# BLACK HILLS ENERGY - HWY 94 ENOCH RD - MAYBERRY

## GRADING AND EROSION CONTROL PLAN EL PASO COUNTY, COLORADO OCTOBER, 2021

EPC STORMWATER REVIEW COMMENTS  
IN ORANGE BOXES WITH BLACK TEXT

PROJECT NAME: COLORADO ELECTRIC - MAYBERRY 6" LINE  
PROJECT ADDRESS: EL PASO COUNTY, CO

SHEET TITLE:  
**GENERAL NOTES & QUANTITIES**

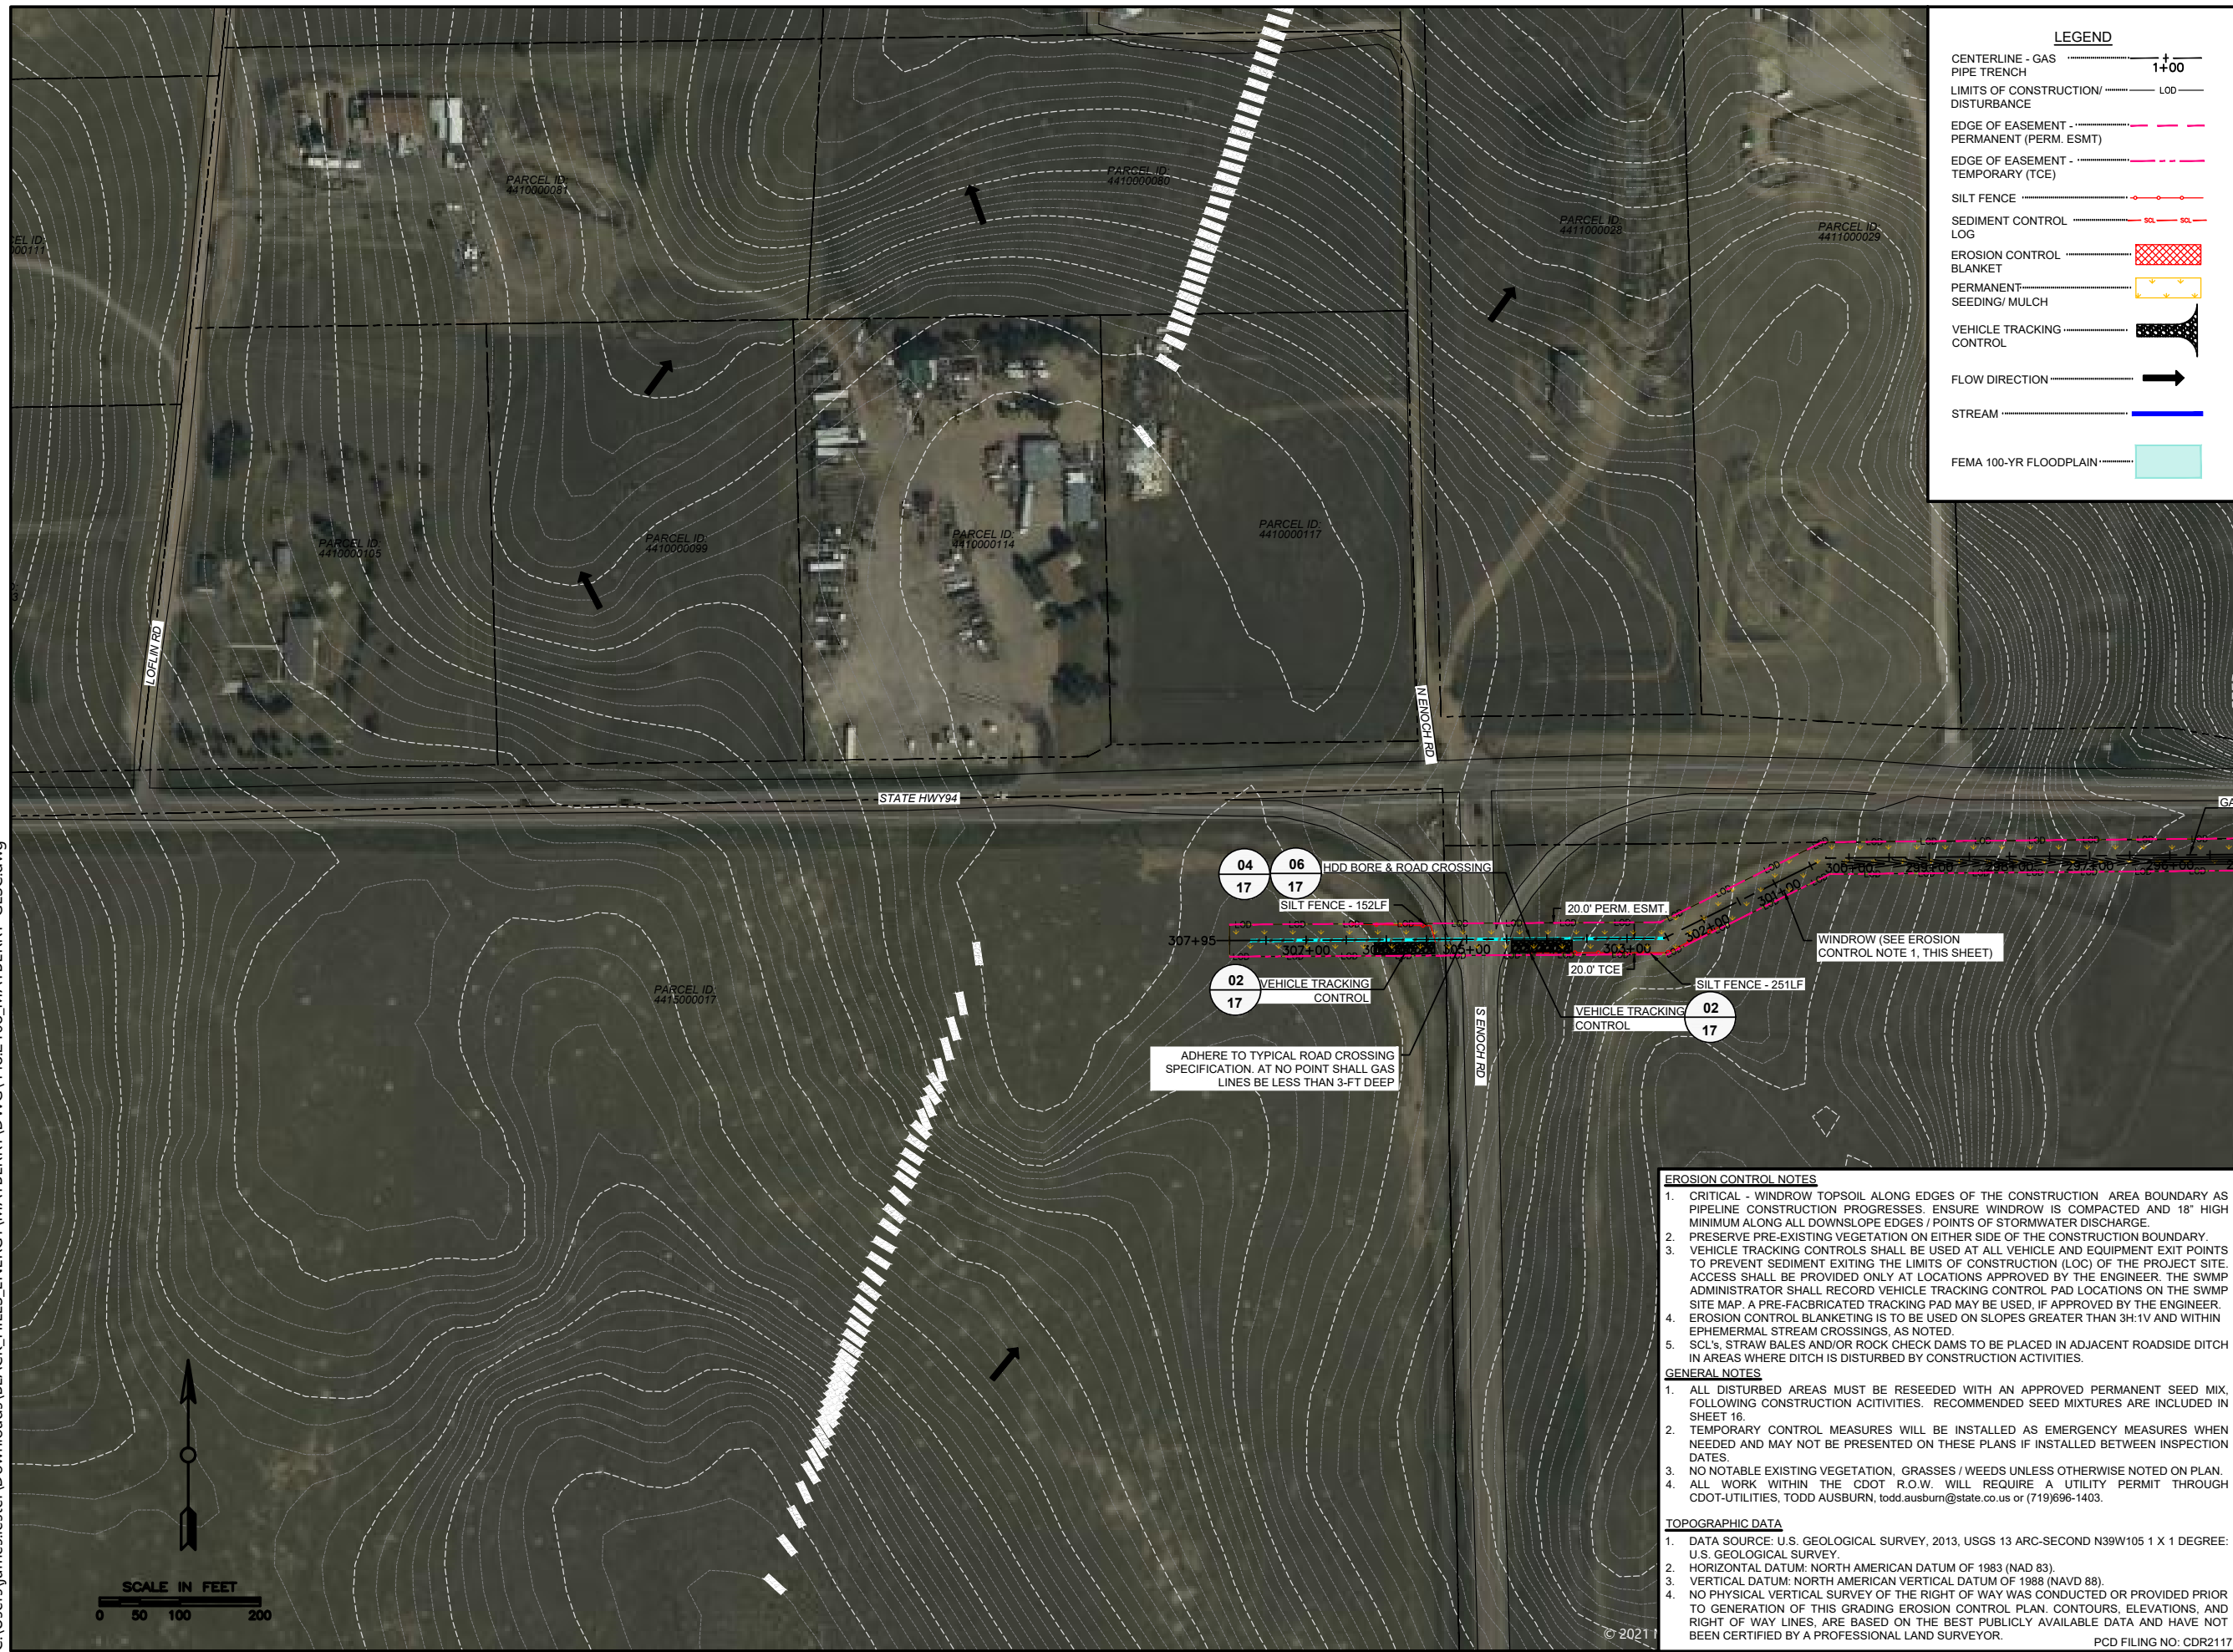
Revise these notes to match those shown in the GEC Checklist.

ISSUE DATE:	12-06-2021
SHEET NUMBER:	04

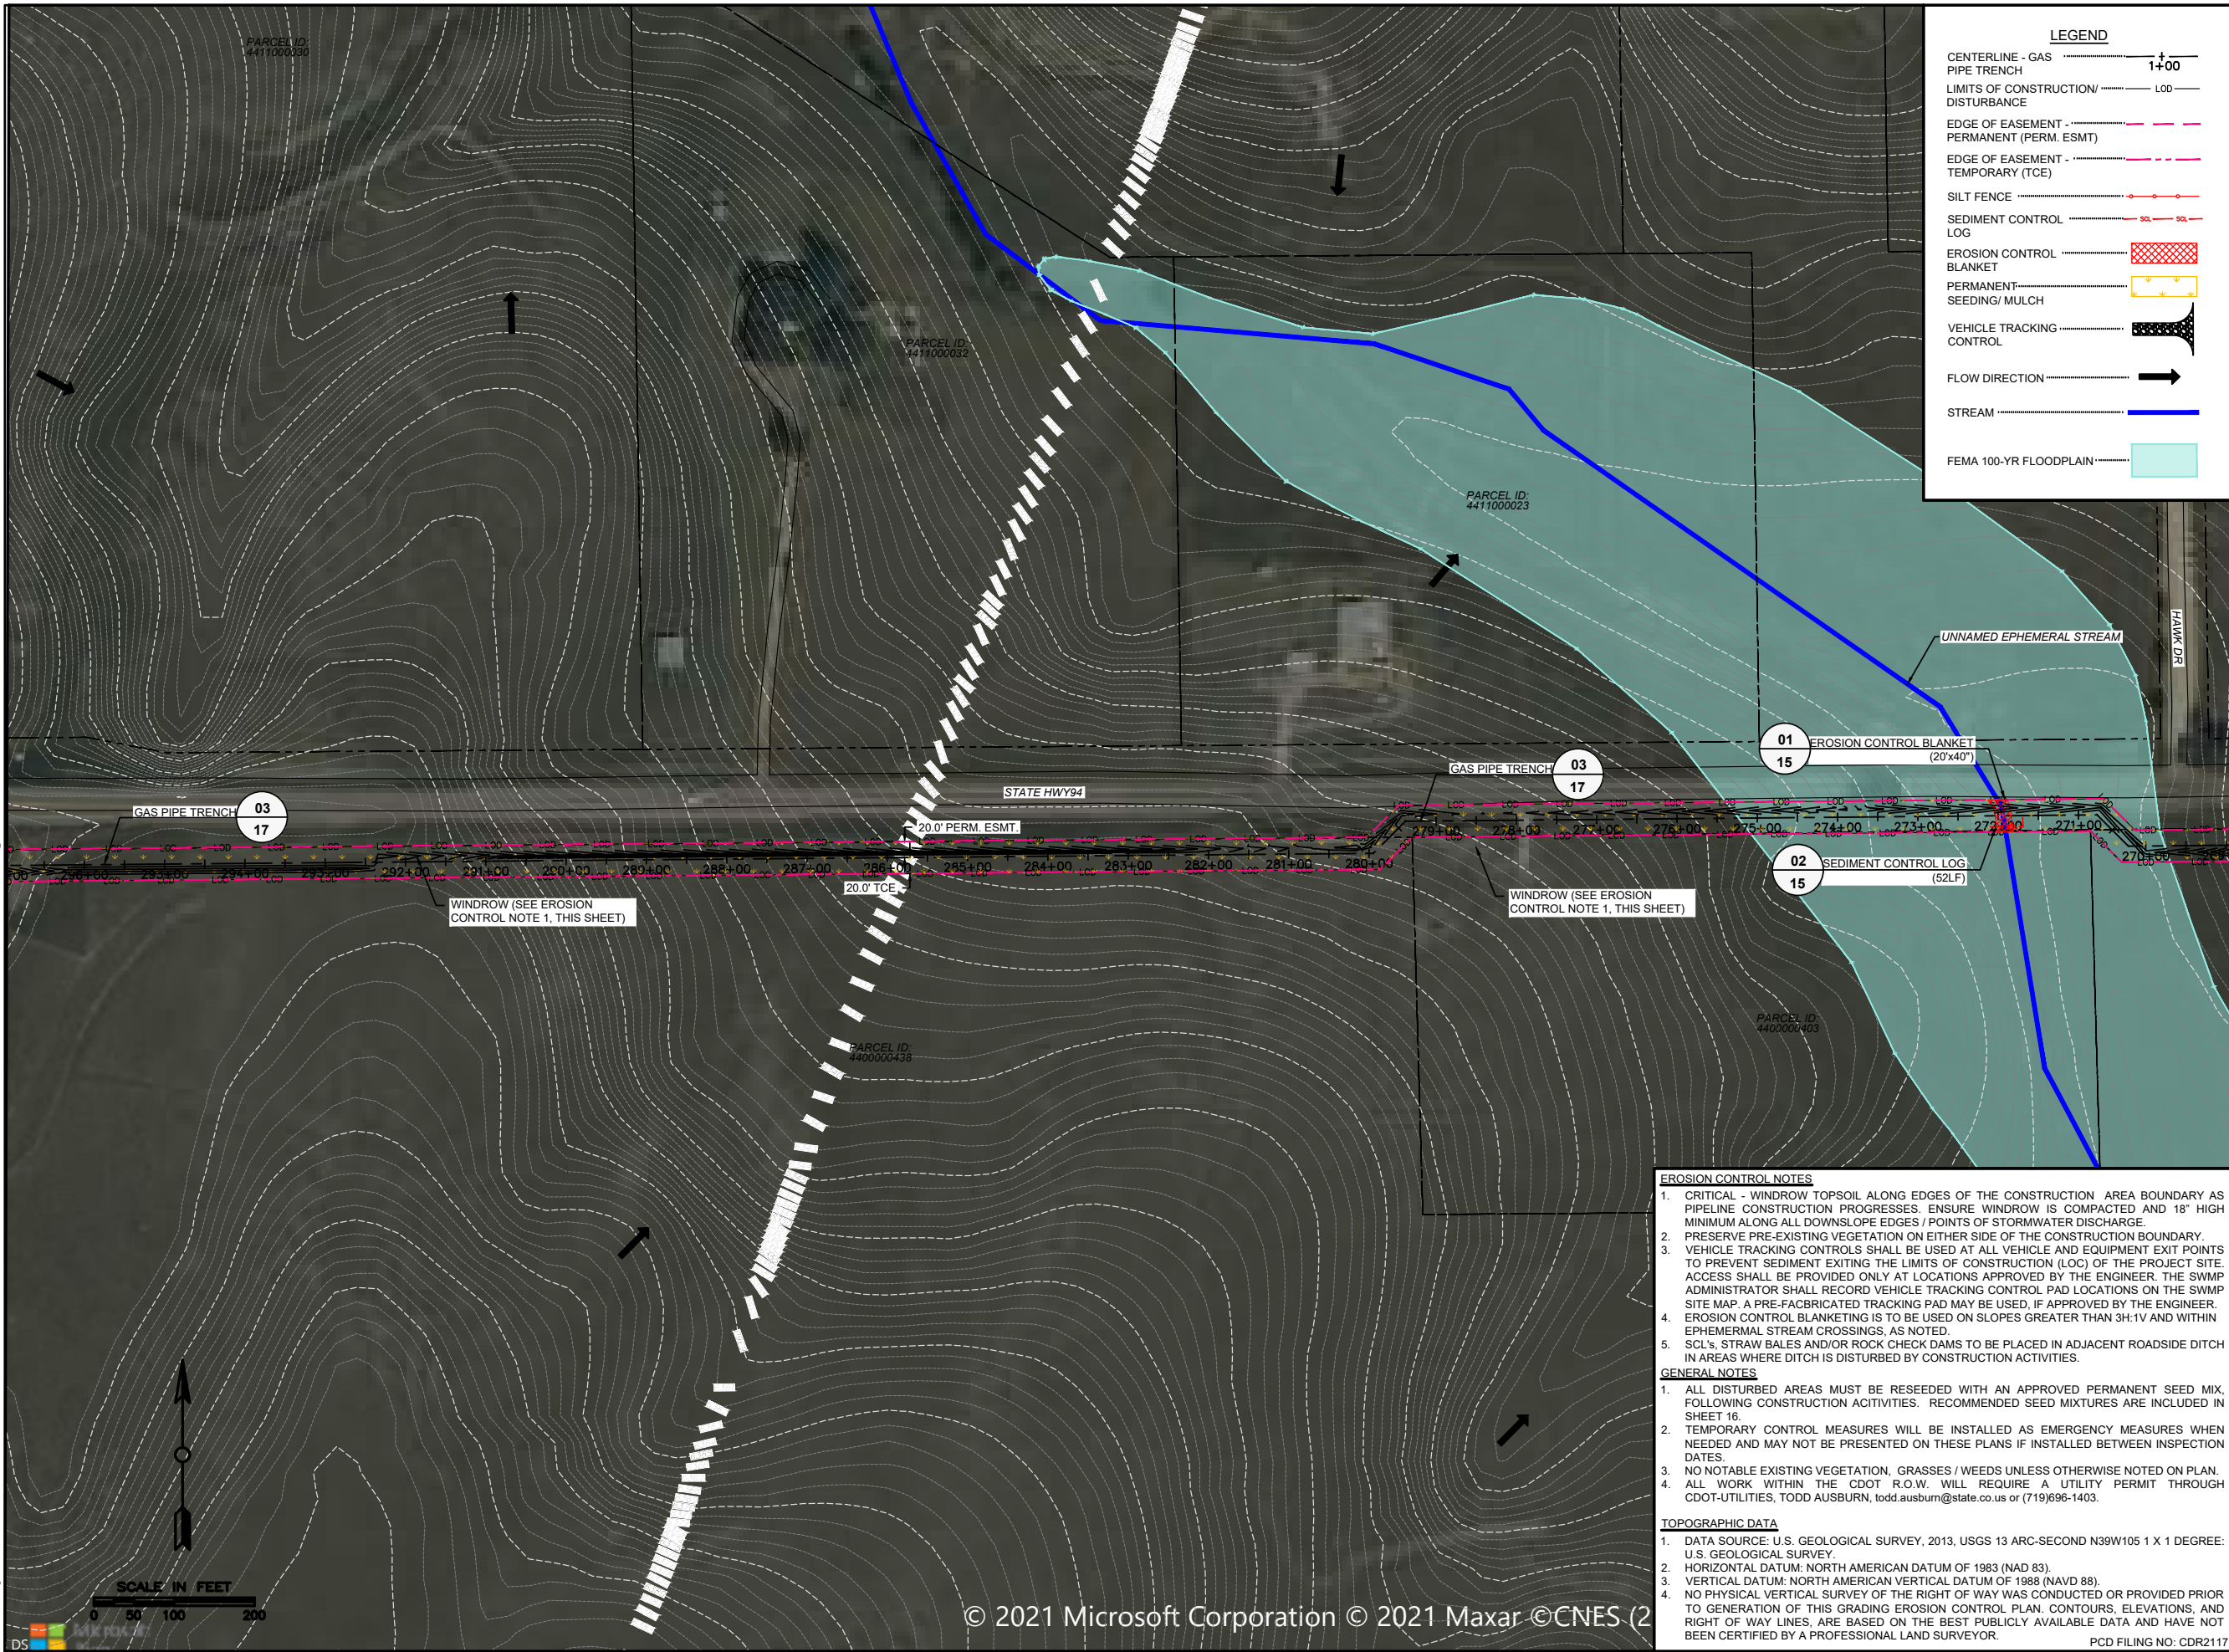
Please label easements on all sheets if reception numbers are known.

State that SCL's, straw bales, and/or rock check dams will be placed in adjacent roadside ditch as needed since it appears that ditch will be disturbed.

Silt fence not appropriate in concentrated flow applications. Use a different BMP.

**06 TYPICAL ROAD CROSSING**

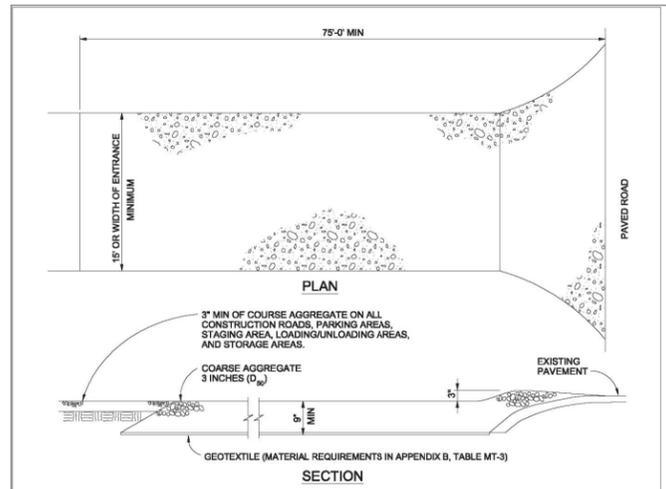
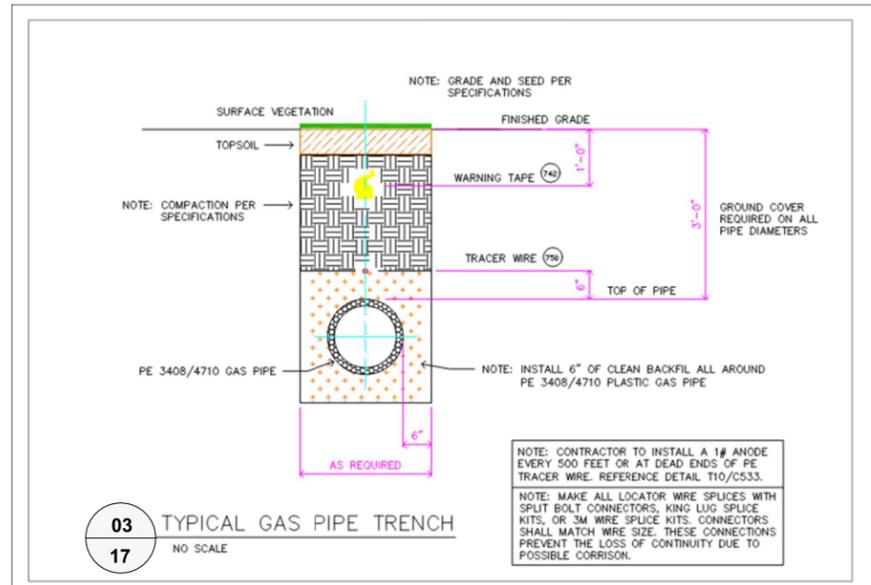
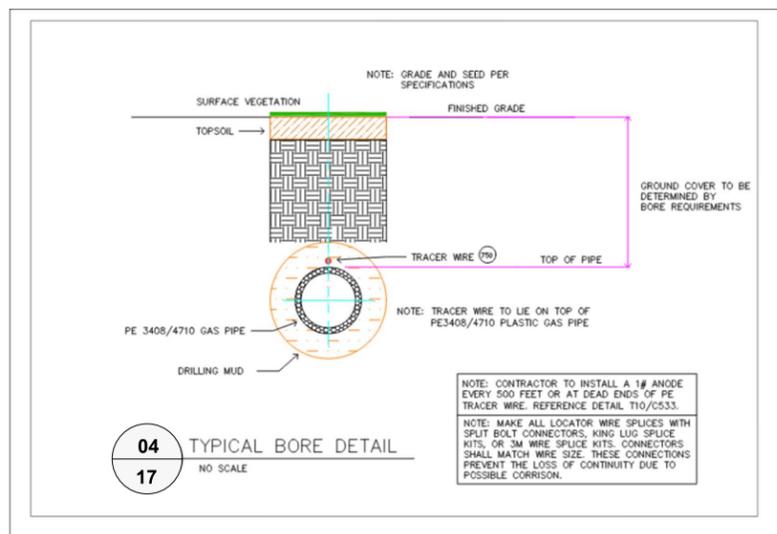
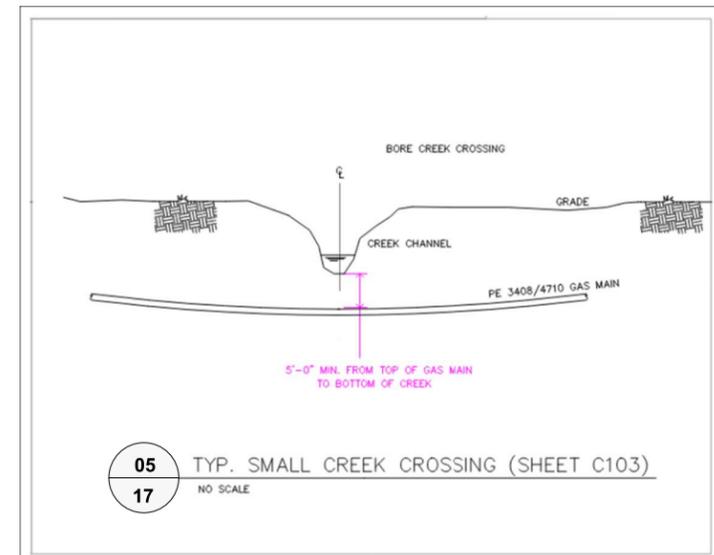
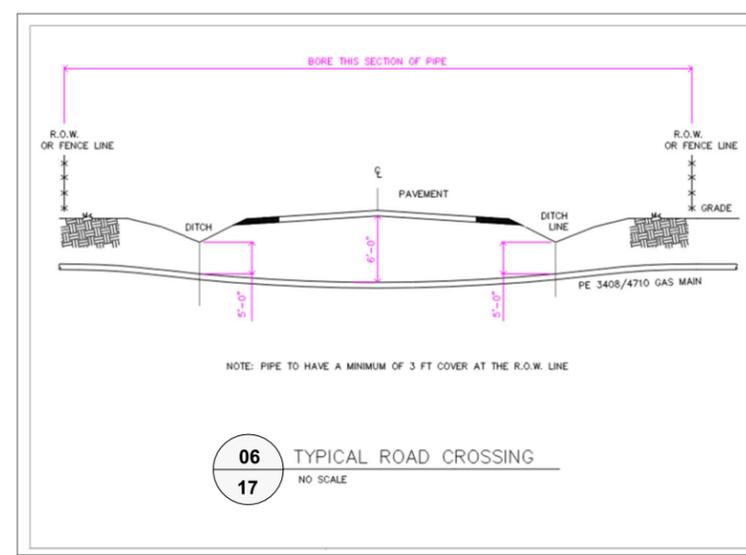
Please provide a callout for the detail of the road cross-section that shows elevation of line in reference to the road surface elevation. Please note per ECM 4.3.6.4 bullet point 1, at no point shall gas lines be less than 3 feet for main lines and no less than 2.5 feet for service lines.
